Re planning application no. 3/2026/0242

Planning Application Reference No.: 3/2026/0242

Address of Development: 31 Castle View Clitheroe BB7 2DT

Proposed North Elevation - 1:100

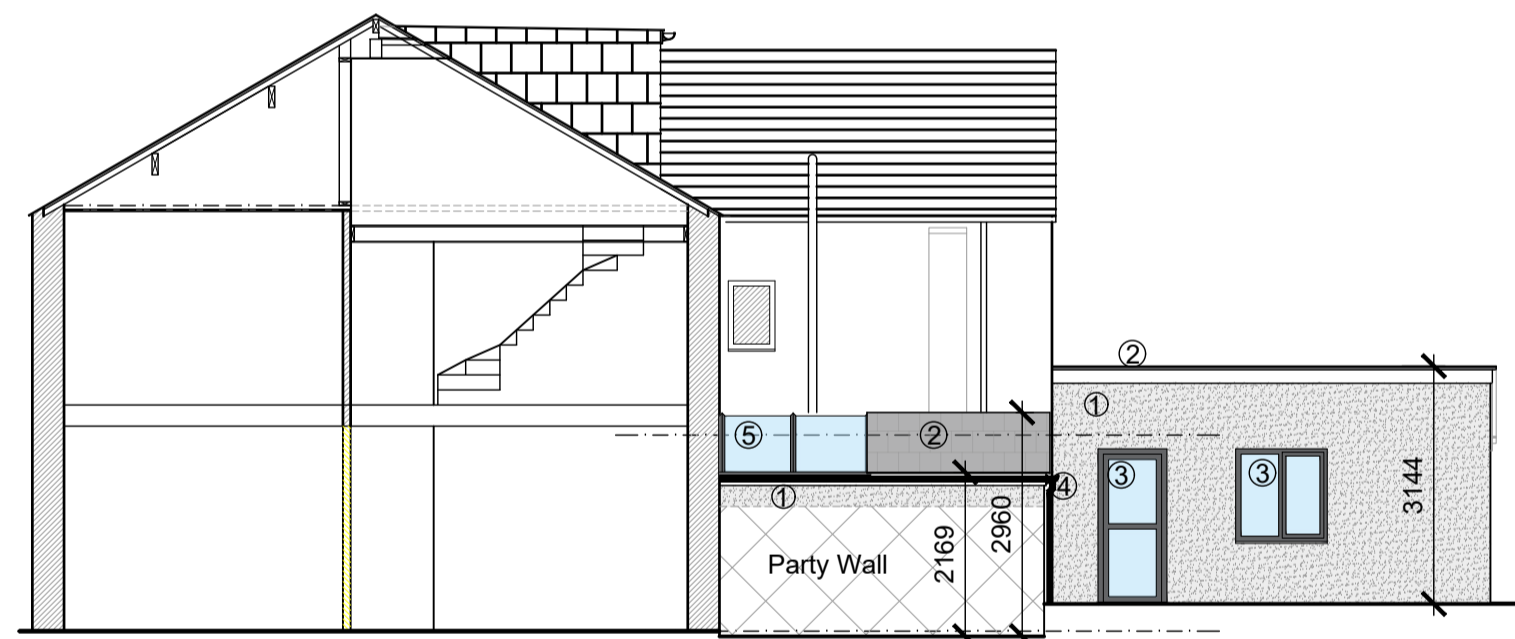
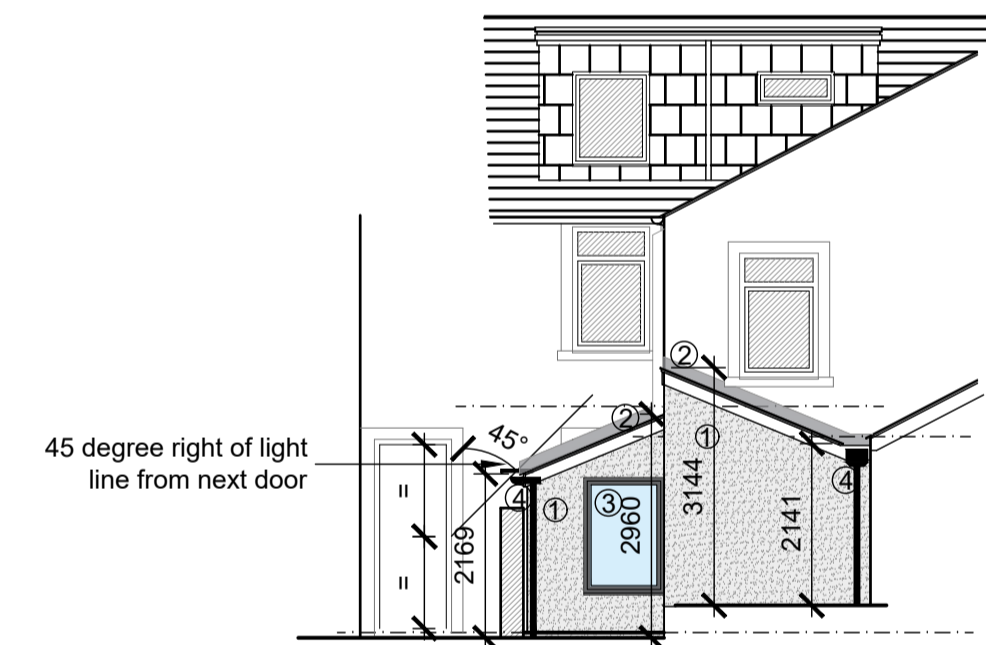
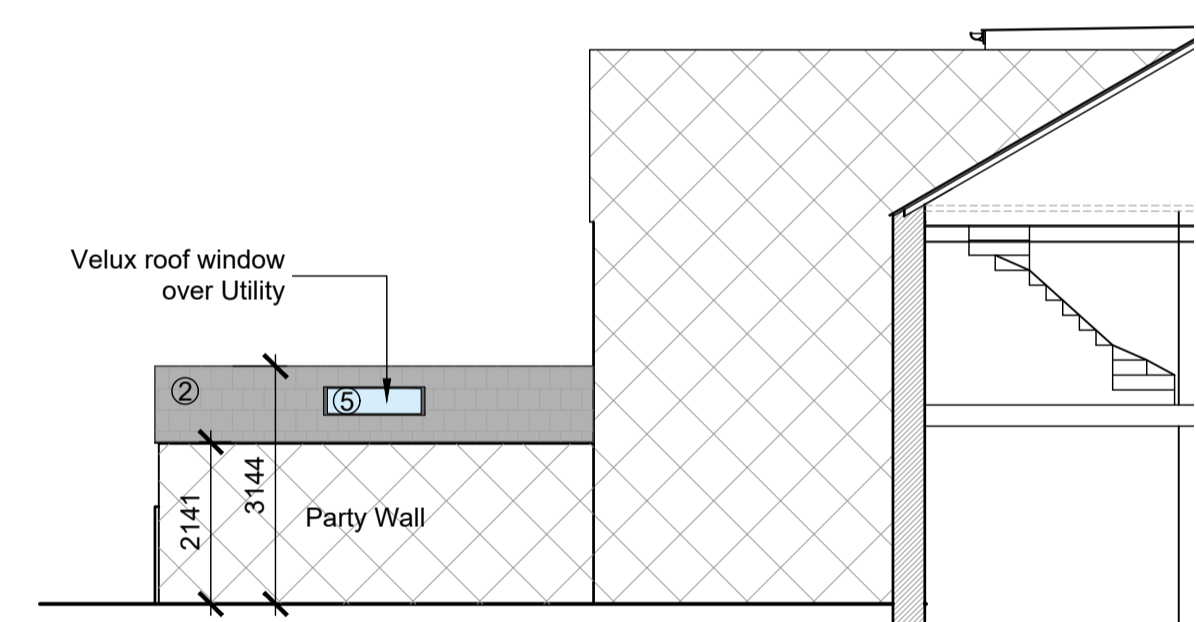
Comments: The proposed utility/toilet room extension at No.31 Castle View will look extremely tall and ugly from [REDACTED], [REDACTED] and [REDACTED] windows.

It must surely be possible to excavate making a lower height extension thereby not reducing light both outside and inside [REDACTED]?

It would be a lot more in keeping with the area to have either a pitched roof, as at No`s 27 and 29`s or a flat roof as several have on Buccleugh Avenue nearby. Both these options would be far more acceptable than the one proposed.

Also, it seems a mystery how waste water from guttering collecting water from No`s 29 and 31 will be disposed of?
